Cottam Solar Project

Schedule of Changes (Deadline 2)

PINS Reference: EN010133
Document Reference: EX1/C8.1.7_A
The Infrastructure Planning (Examination Procedure) Rules 2010
Rule 8(1)(k)

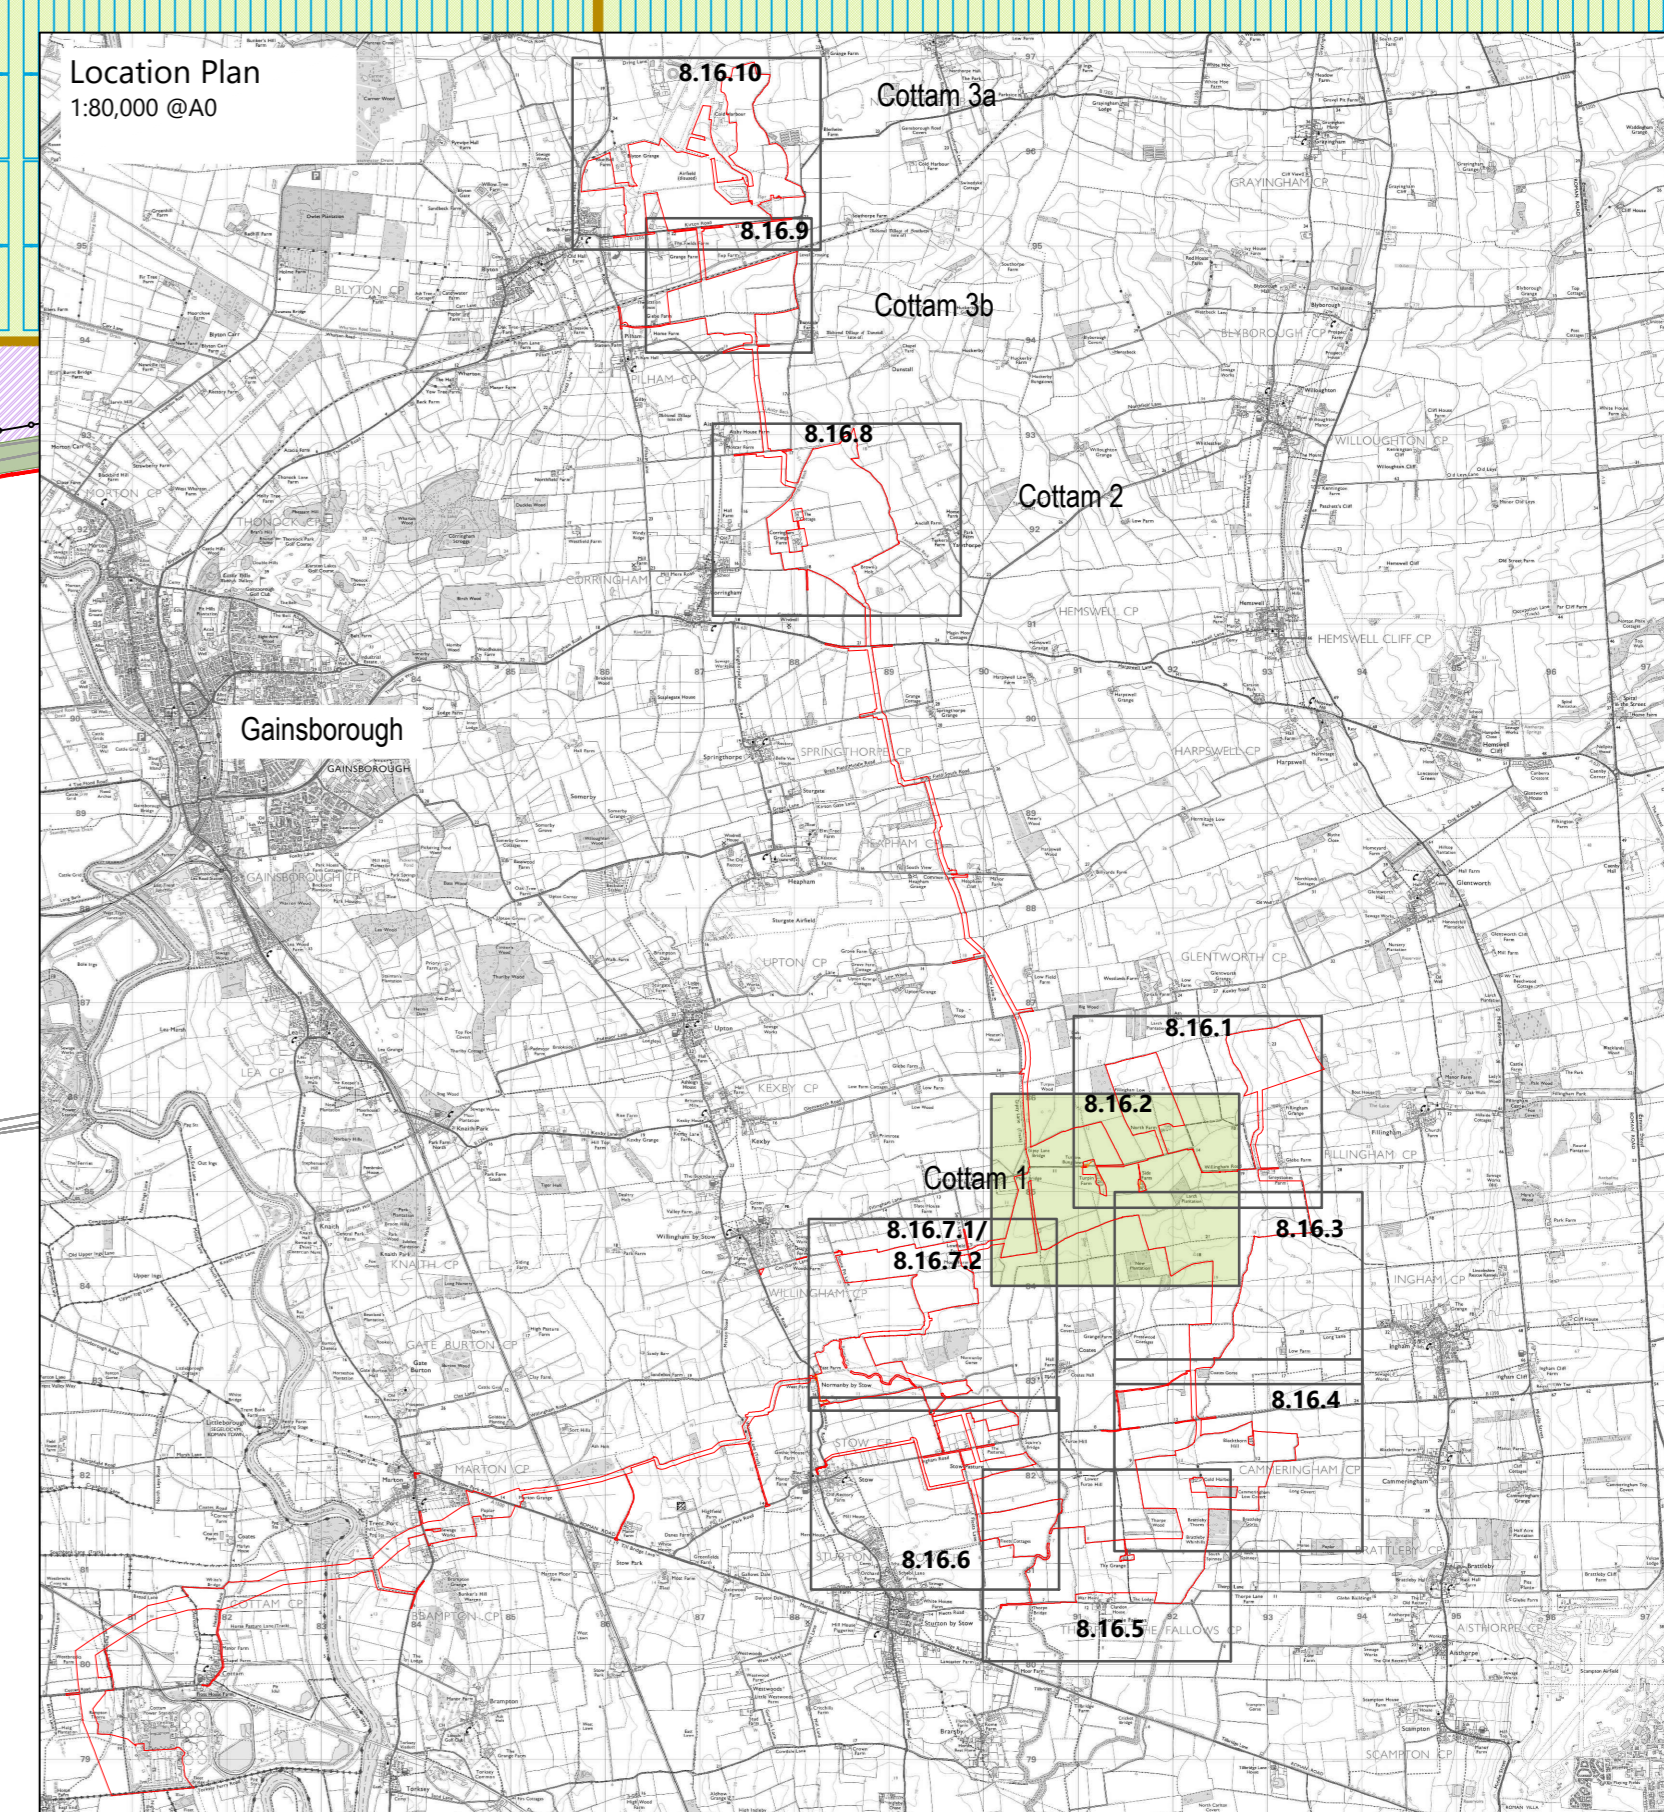
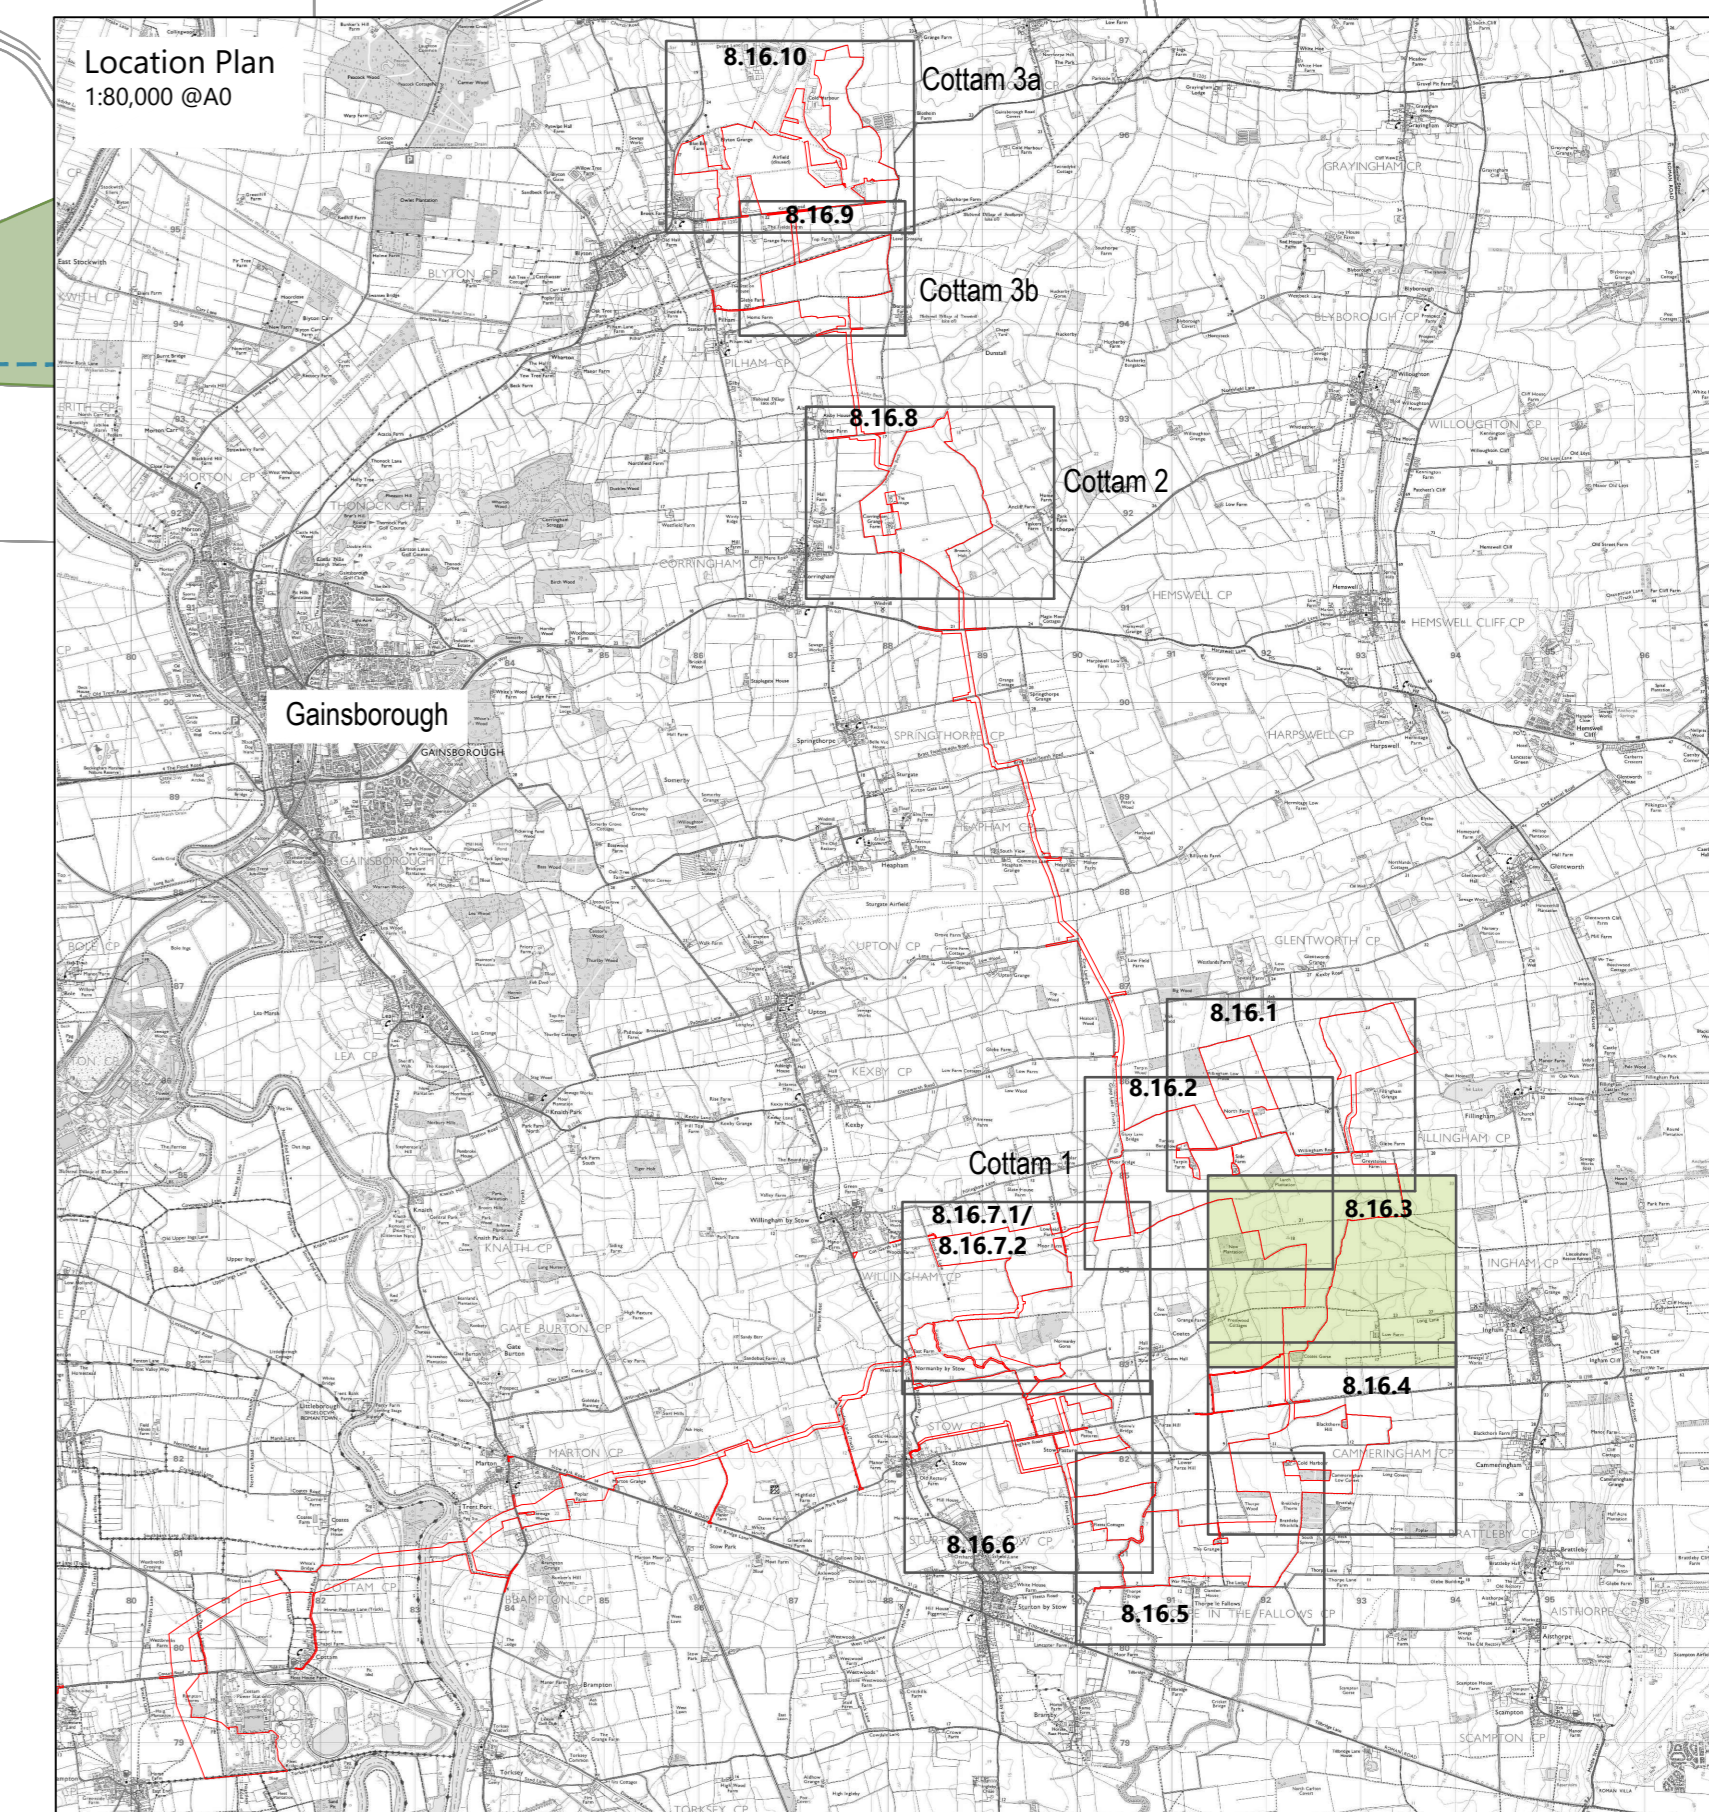
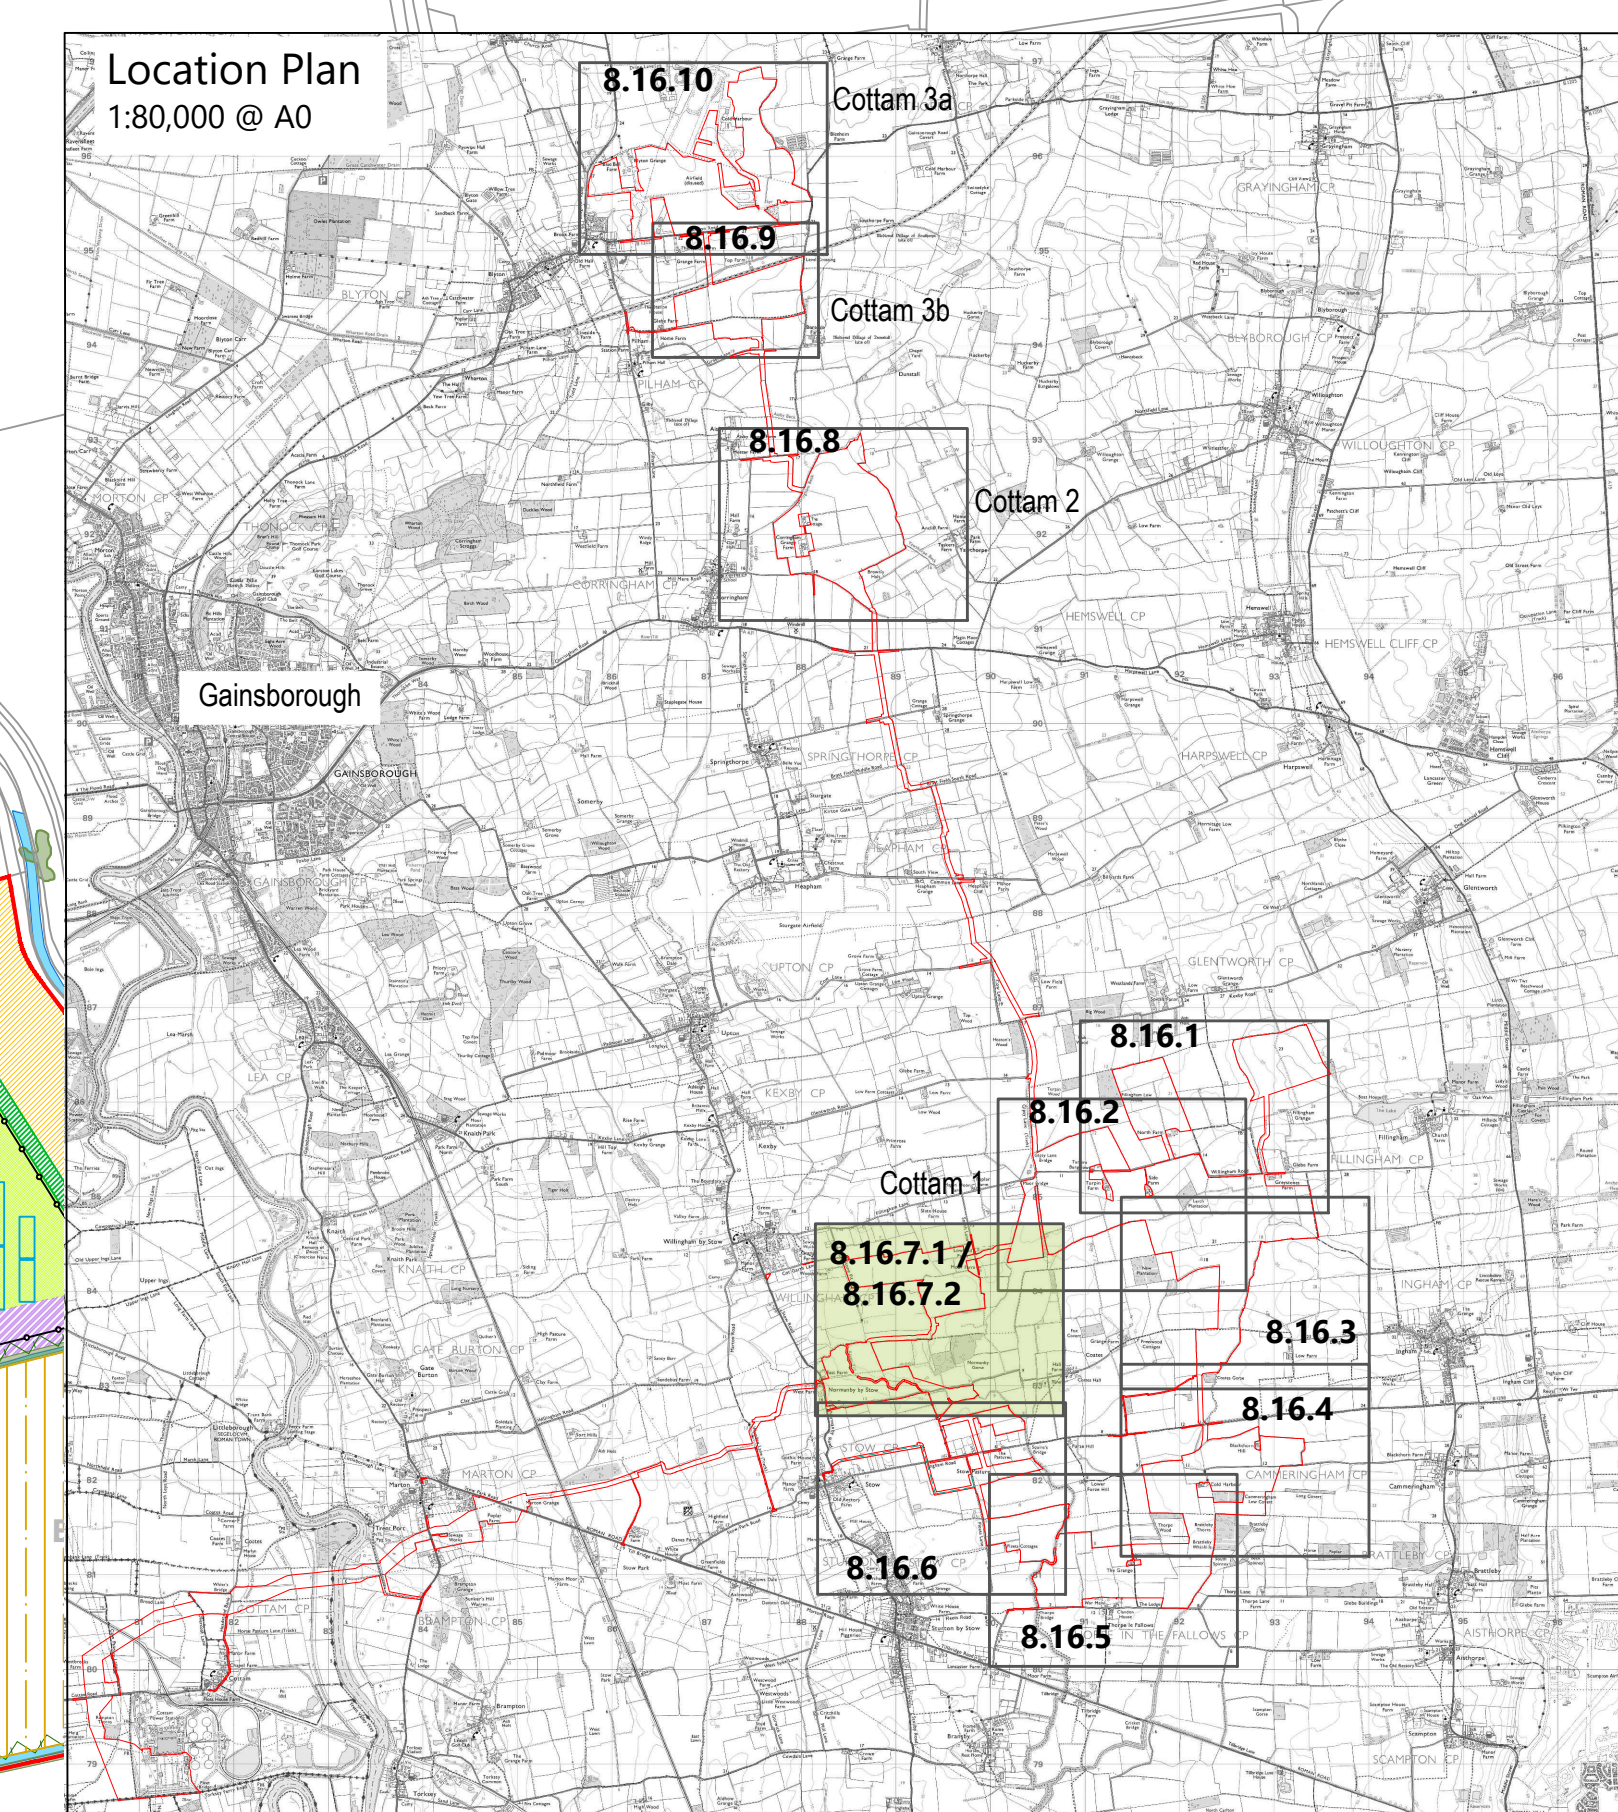
C6.4.8.16.1 to C6.4.8.16.10 Landscape and Ecology Mitigation and Enhancement Plans	[APP-305 to APP-315]	Revision A [EX1/ C6.4.8.16.1_A to EX1/ C6.4.8.16.10_A]	Deadline 1 17 October 2023	Correction of typos, to show additional hedgerows to be removed and to provide clarity of IDB Drain locations.	Minor editorial changes for clarity.
C6.5 ES Non-Technical Summary	[APP-336]	Revision A [EX1/C6.5_A]	Deadline 1 17 October 2023	Paragraphs 6.3.14 to 6.3.16, and 6.3.20 to 6.3.21, updated clarifying as to which part of the Site, and which assessment period the effects relate to.	To provide clarity and consistency and minor editorial changes.
